Re: Oxbow and Coors Pavilion Developments Appeal at NM 45 and St. Joseph's Drive

I received your request for appeal to NMDOT District Three's non-concurrence on the Oxbow and Coors Pavilion Development Traffic Impact Study (TIS) as submitted. According to the letter dated August 15, 2022, NMDOT has concerns with the safety operations at NM 45 (Coors Blvd) and St. Joseph's Drive. NMDOT strives to maintain a multimodal facility at its highest level of safety, therefore meeting the minimum levels of services as outlined in the State Access Management Manual.

Justin Gibson, PE  
District Engineer  
NMDOT District Three

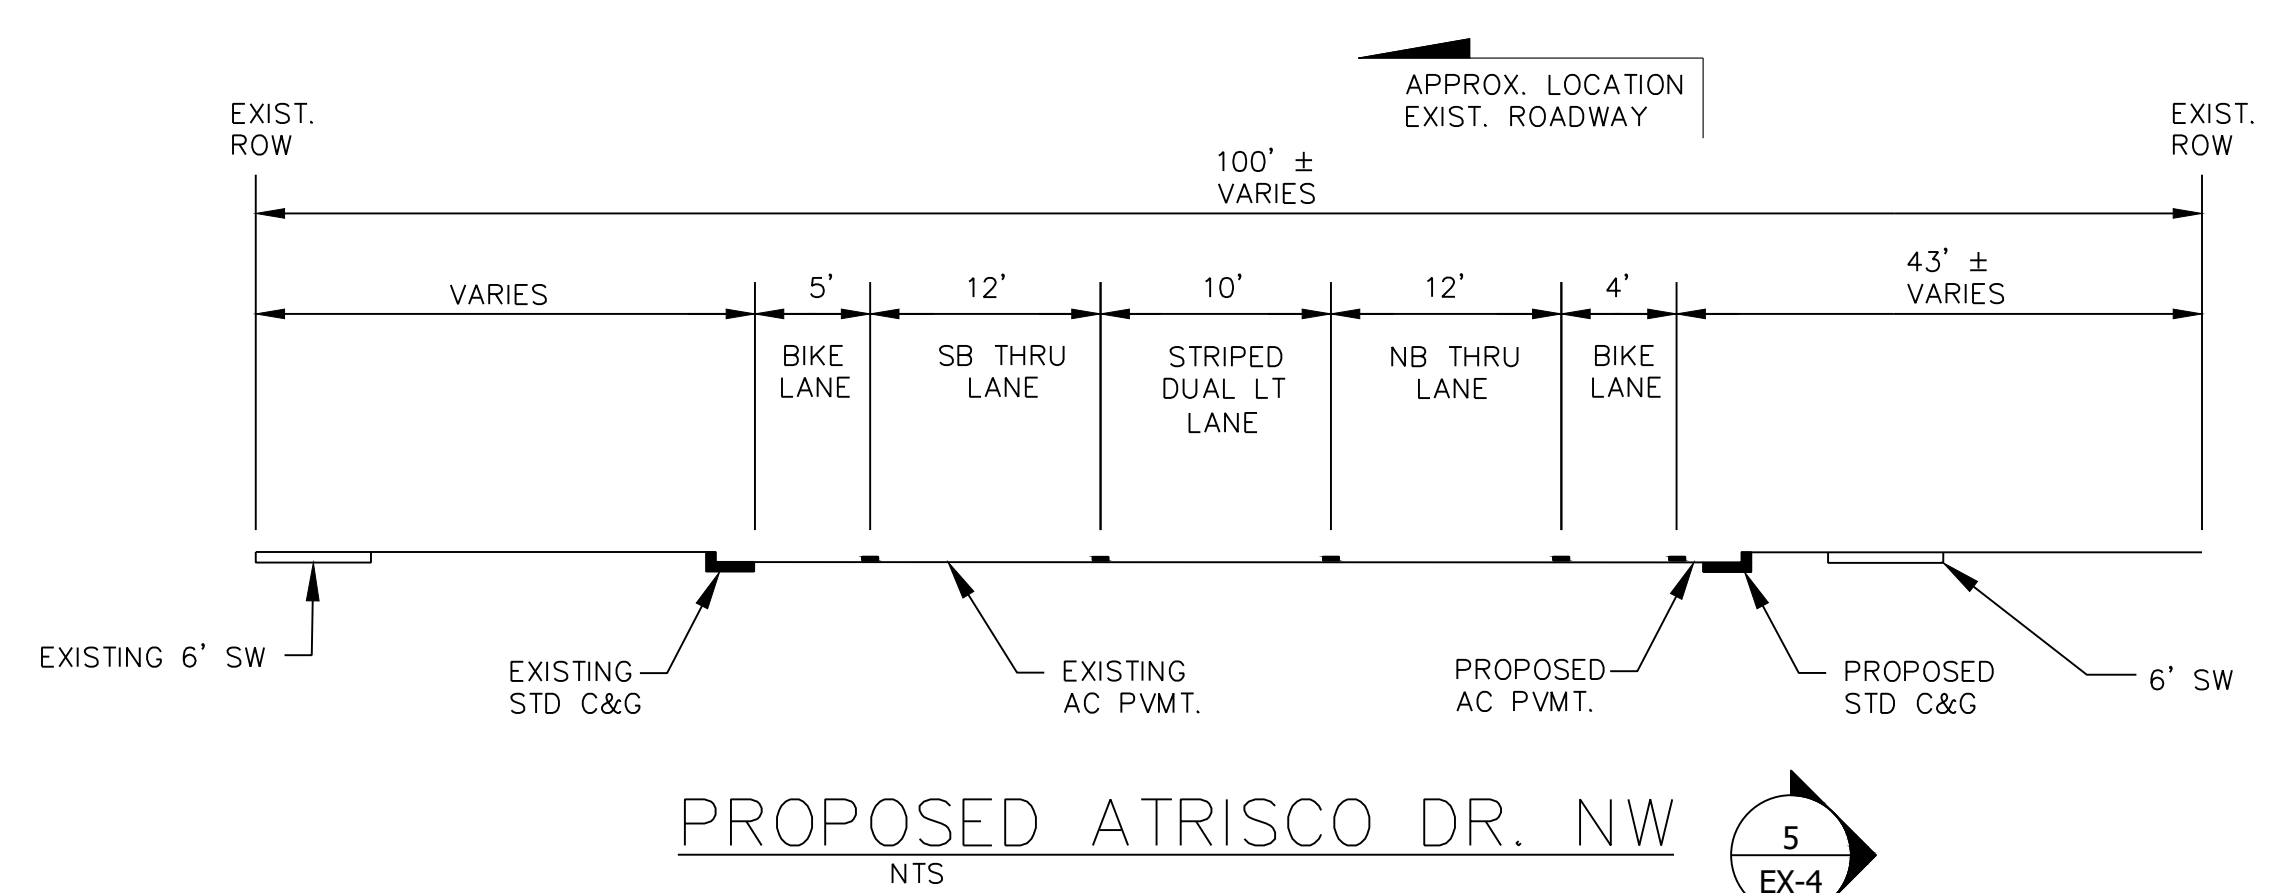
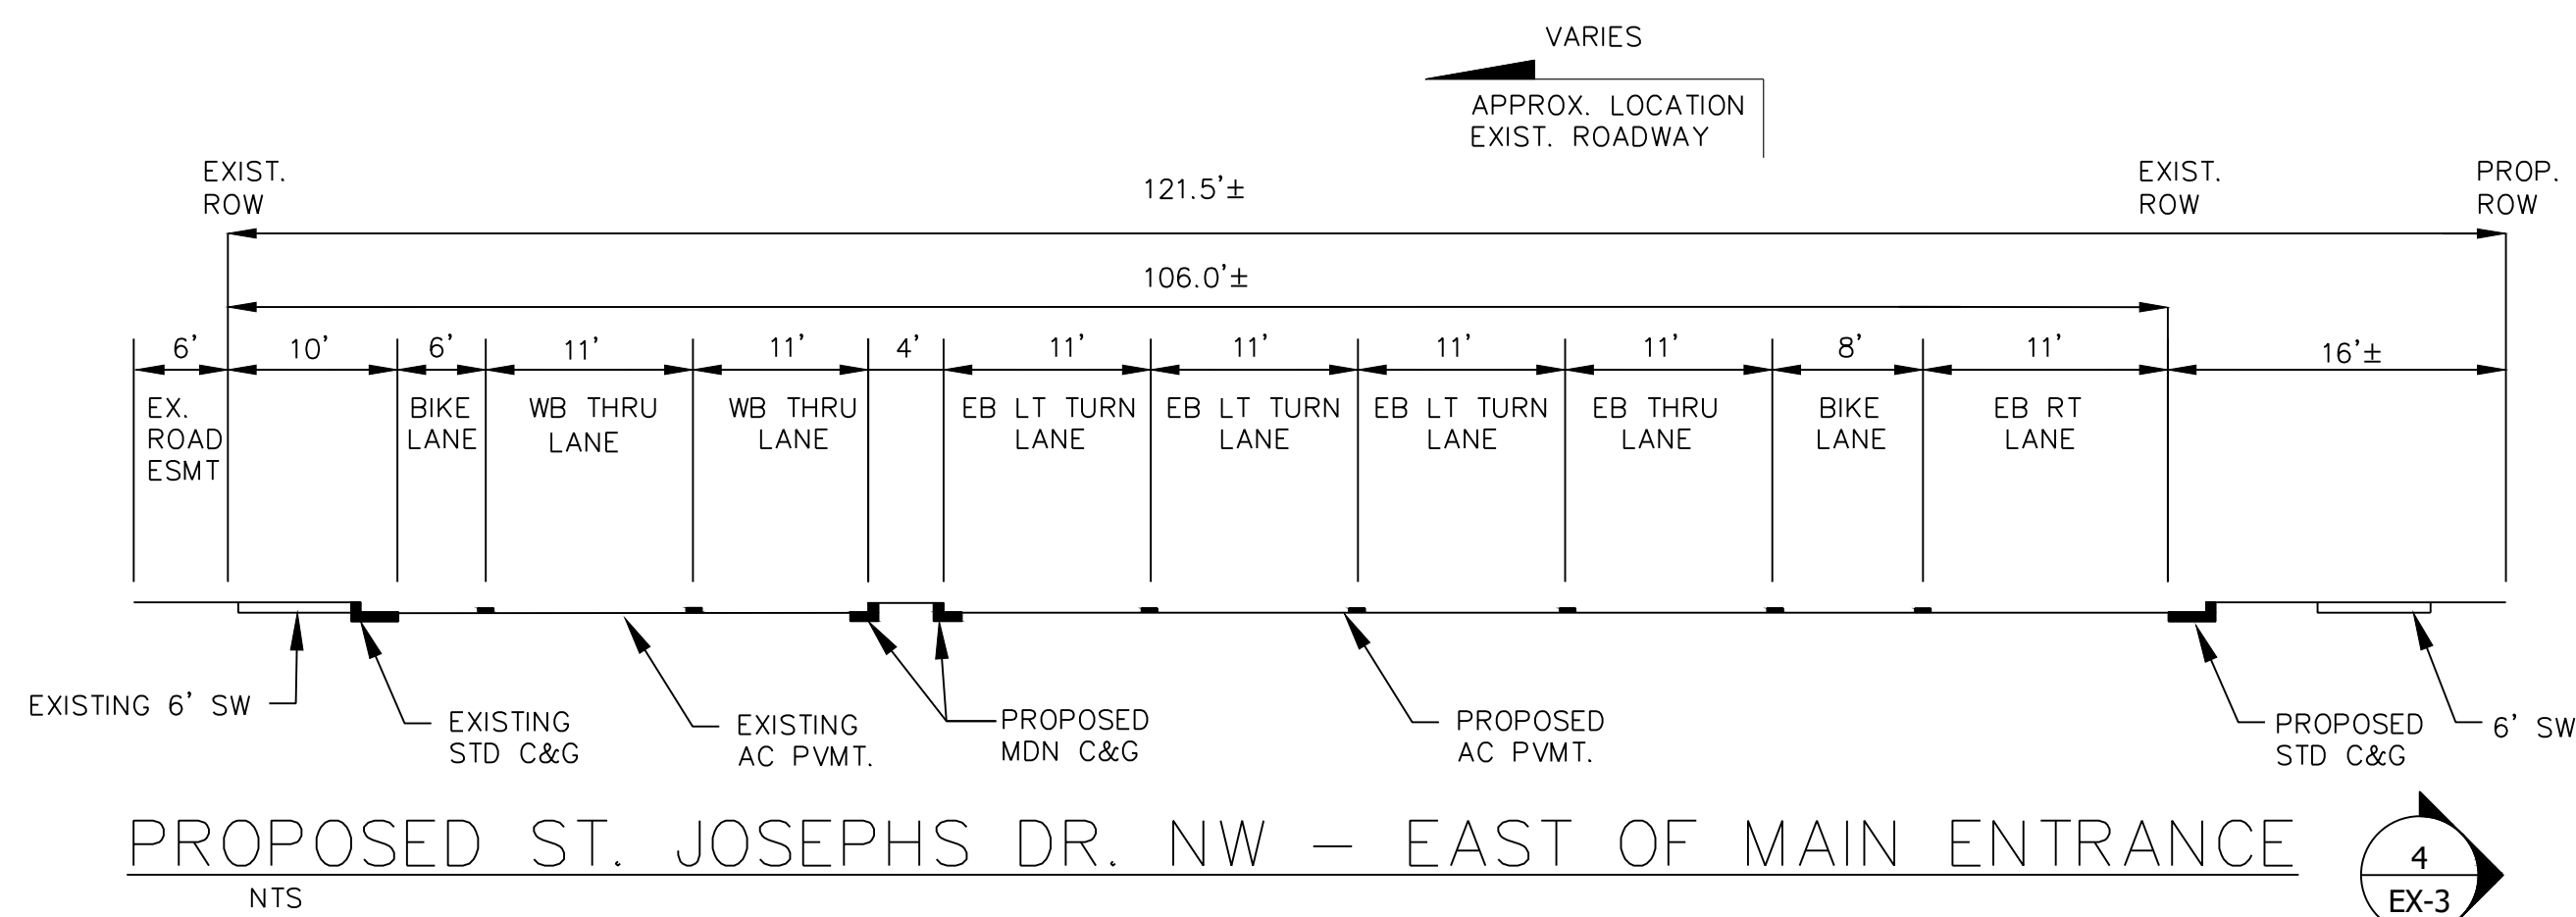
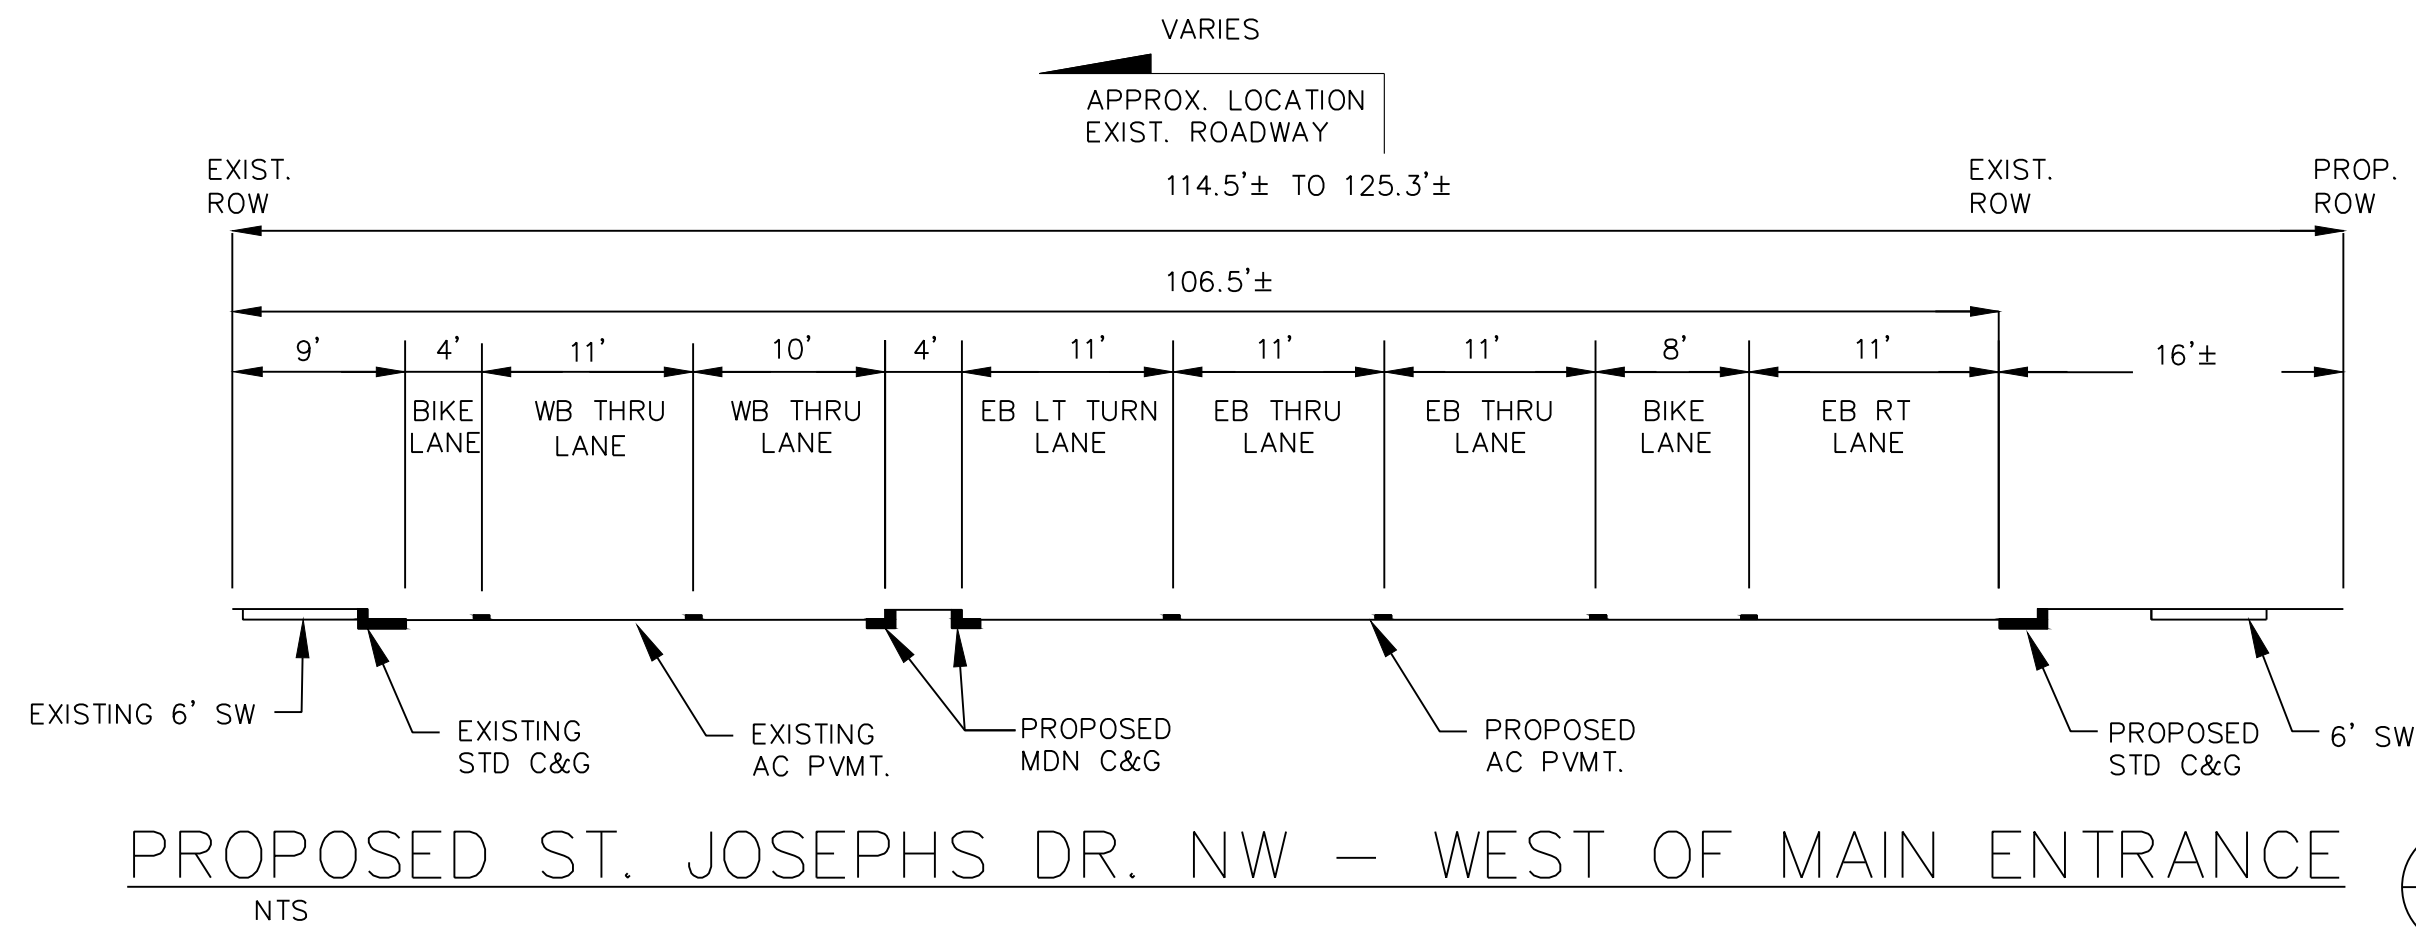
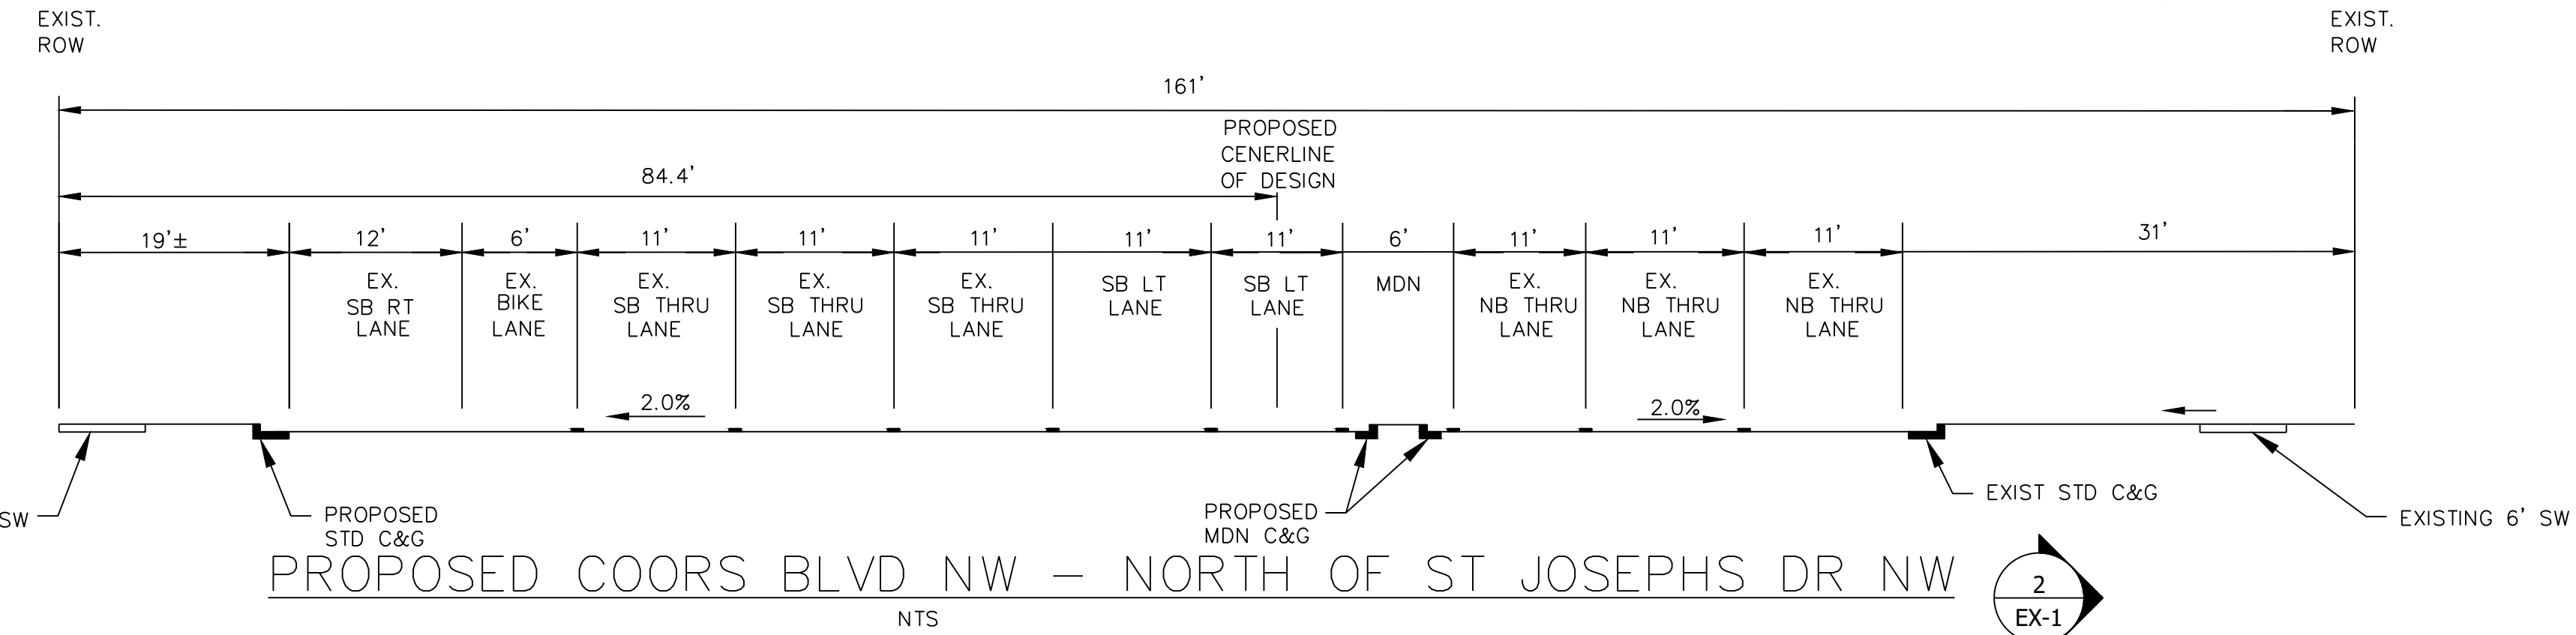
- The development shall propose a design on NM 45 that meets NMDOT's design standards for lane widths, median widths and design turning templates.
- The development shall obtain professional engineering services who are qualified to provide oversight of the signal operations and management on NM 45 at the signalized intersections of Western Trail, St Joseph's Drive and Sequoia Rd. This work shall include daily/weekly monitoring and management of the signal operations for the duration of construction of this development through the full build of this development plus one year. This work may be performed utilizing the existing Automated Traffic Signal Performance Measures (ATSPM) System owned by the City of Albuquerque.
